Arun District Council

Ref. Planning Application R/211/19/PDH

Further to the Council's letter of 9th. September 2019 regarding the above Application, I have now had opportunity to examine the submitted drawings for same and would like place on record our formal Objection to the proposed extension.

DRAWING STATUS:	PLANNING
CLIENT:	MR & MRS JAGGS
PROJECT:	35 SEA AVENUE, RUSTINGTON
DRAWING:	AS PROPOSED
DRAWN:	JT
DATE:	AUGUST 2019
JOB NO.	1519
SCALE	1:100 @ A1
REV.	
DRG. NO.	D.001

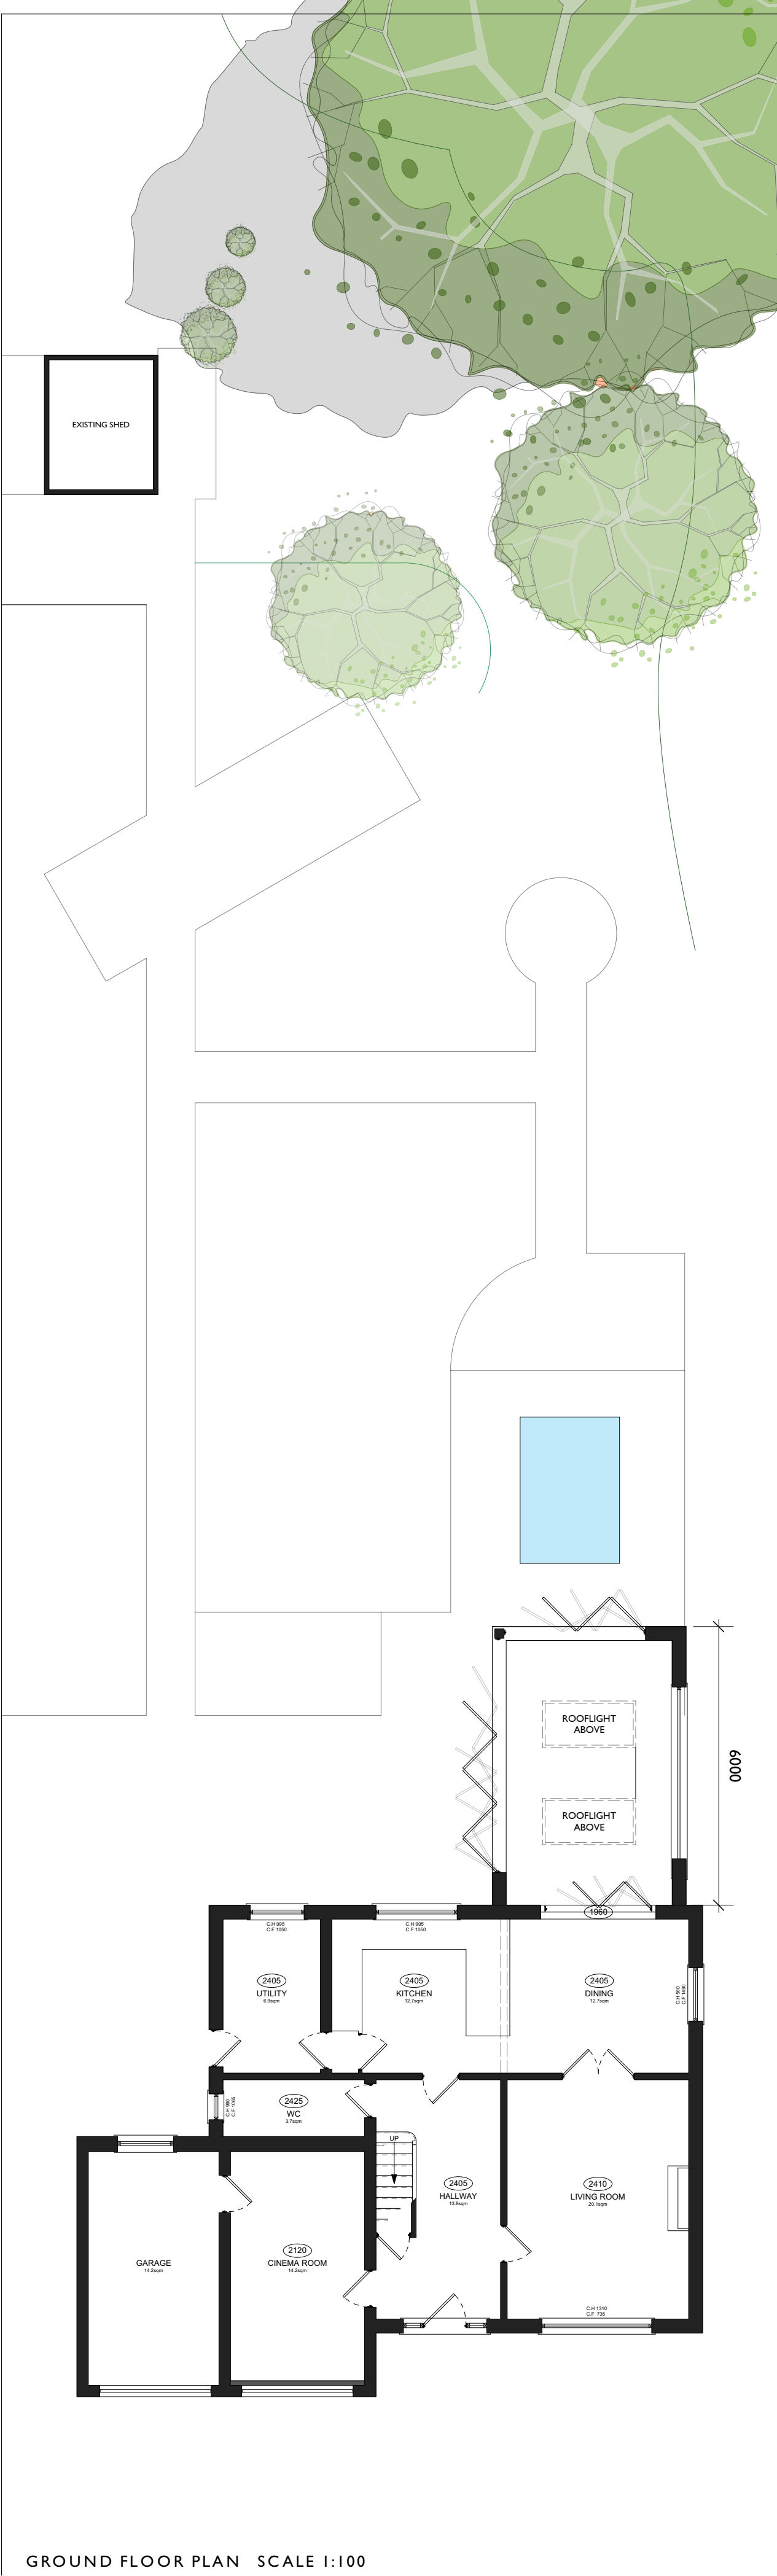
Firstly, the fence between our house and the Applicant's existing conservatory is flanked by trees/shrubs to a height of more than 4 metres, and this fact alone puts our own conservatory into shade. The proposed extension will, if approved, prolong an approximately 4 metre long conservatory wall to 6 metres, and should the Applicant then elect to plant a similarly high 'green wall' to mask the increased length of the new building we will suffer shadowing to our living room as well. The loss of natural light is already considerable; agreeing to further shade would be unreasonable.

Secondly, while we understand (and indeed share) the Applicant's desire for privacy (viz. the overgrown shrubbery/trees mentioned above), the prospect of a 50% increased length in his proposed conservatory will inevitably contribute to an infringement of the private use of our own garden by virtue of the increased number of people thereby enabled to be housed therein. Greater living space invites greater use and therefore the potential for a greater level of noise to neighbouring dwellings.

Finally, we note that the proposed extension has opted for a flat roof illuminated by roof lights; this is hardly in keeping with the appearance of the house proper, whose own roof and double garage

enjoy a more traditional gabled design that blends in with its neighbours' dwellings. As it stands, it would therefore seem to be out of character with its surroundings.
